CITY OF ALBUQUERQUE

Re: Bob's Burgers
~~4506-4588~~ Central Ave SW
Request Permanent C.O. - Accepted
Engineer's Stamp dated: 11-6-13 (K12D032)
Certification dated: 9-29-14

**Re: Bob's Burgers, West Central/46th Street, Grading and Drainage Plan
Engineer's Stamp dated 11-06-2013 (K-12/D032)**

**Re: Bob's Burgers, West Central/46th Street, Grading and Drainage Plan
Engineer's Stamp dated 07-30-2013 (K-12/D032)**

Drawing file: FINAL / K12D032_GD_SHAHAB_MARKUPS_2013NOV05.pdf

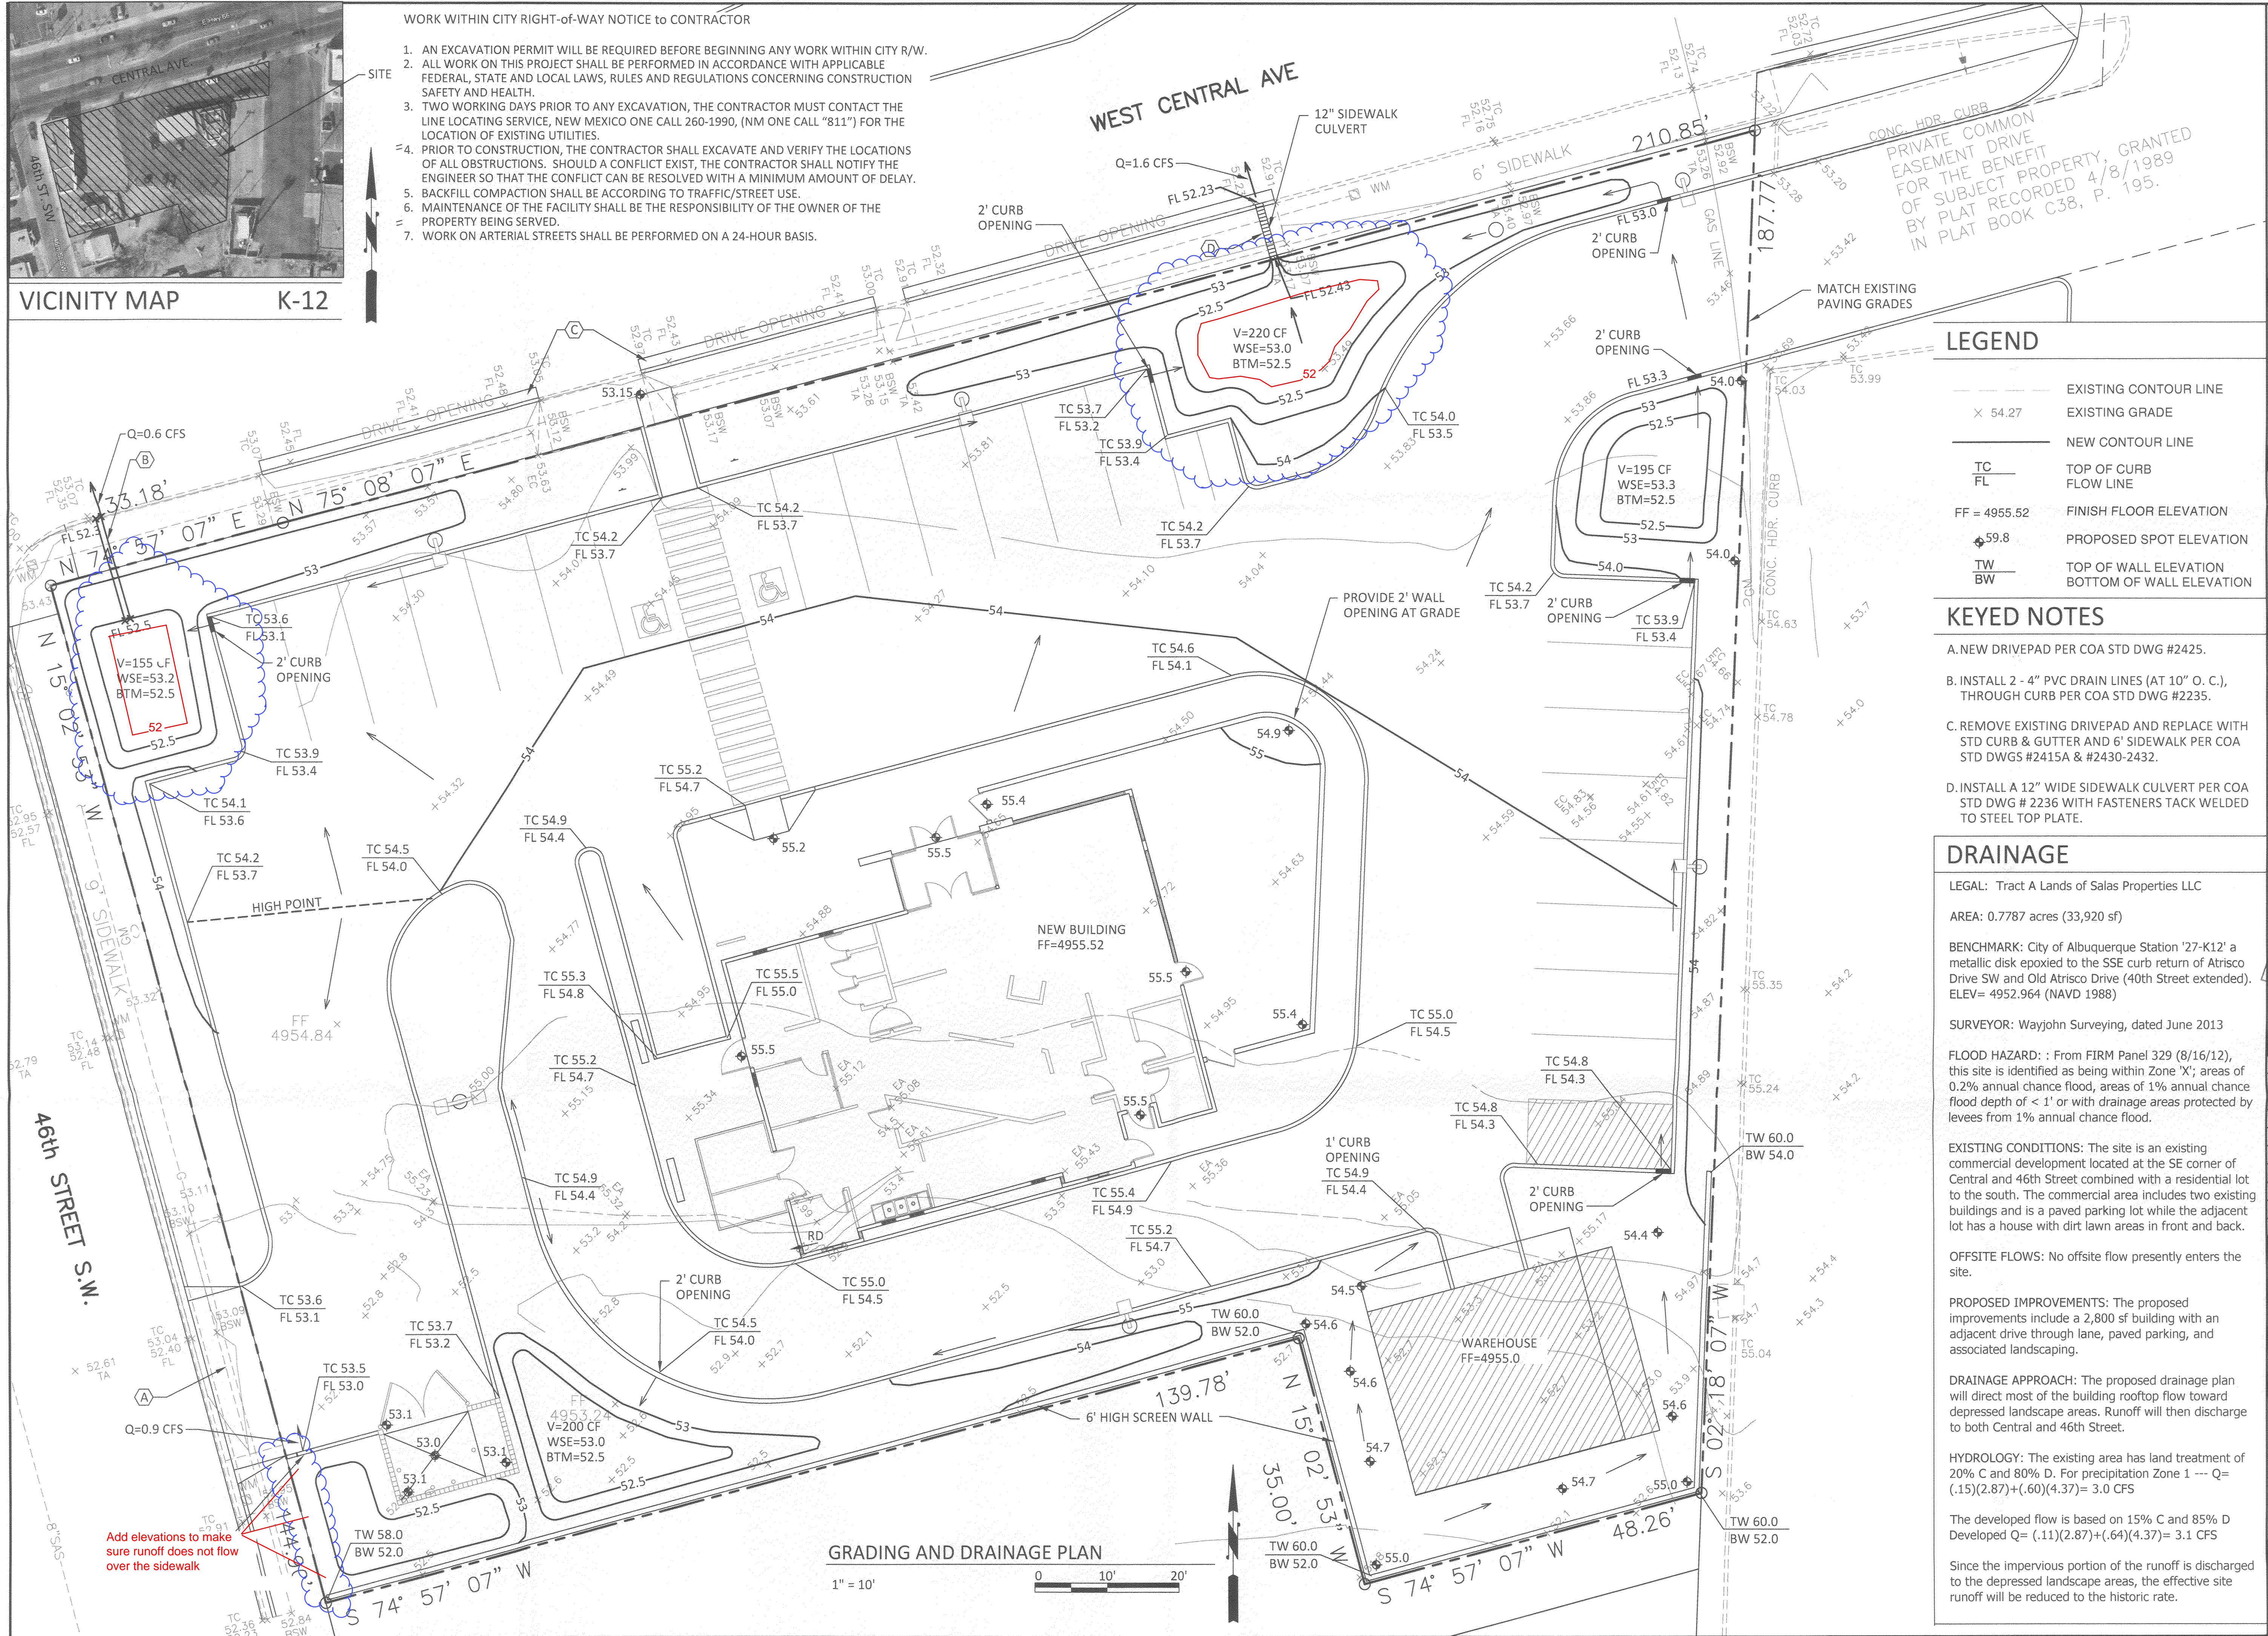
- Both proposed curb penetrations need to reference City Standard Drawing #2235. The SO-19 standard notes need to be added to the grading plan.
- Raise the grades south side of the warehouse to create positive flow to the front.

- Provide additional spot elevations along at the sidewalk connection for the ADA path.
- Provide pond calculations for each of the proposed water harvesting ponds.

- Provide top-of-pond and bottom-of-pond elevations for the ponds along with flow calculations and capacity for the two pipe penetrations along Central Ave. Runoff will not be allowed to drain over the sidewalk.

- Are the sidewalks on the plan proposed or existing?
- The trash enclosure will need to show a drain connection to the sanitary sewer system. Provide additional spot elevations at the corners of the enclosure.

- The driveways which are not being used should be removed and new curb and gutter and sidewalk should be constructed.

1. S O-19 standard notes and curb penetration references have both been added to the plan.
2. Finish grades around the proposed warehouse have been revised.

3. A spot elevation has been added where the sloped walk ($s < 5\%$), meets the Central Avenue public sidewalk.
4. Individual pond volumes are indicated on the Grading plan.

5. WSEs and pond bottoms have been noted along with the specific discharge rate through each curb penetration. The NW penetration has been revised to 2-4" pipes based on the Orifice Equation: $Q = (0.6)(0.087)(32.2)^{1/2} = 0.3$ CFS for a single 4" pipe. The NE penetration has been revised to a 12" sidewalk culvert based on $Q = (0.6)(0.67)(32.2)^{1/2} = 2.2$ CFS.

6. All public sidewalks on Central and 46th Street SW are existing.
7. A waste drain has been added to the refuse area with waste piping shown on the Utility plan.

8. City standard detail references have been added where drives are to be removed and replaced with curb/gutter and sidewalk.
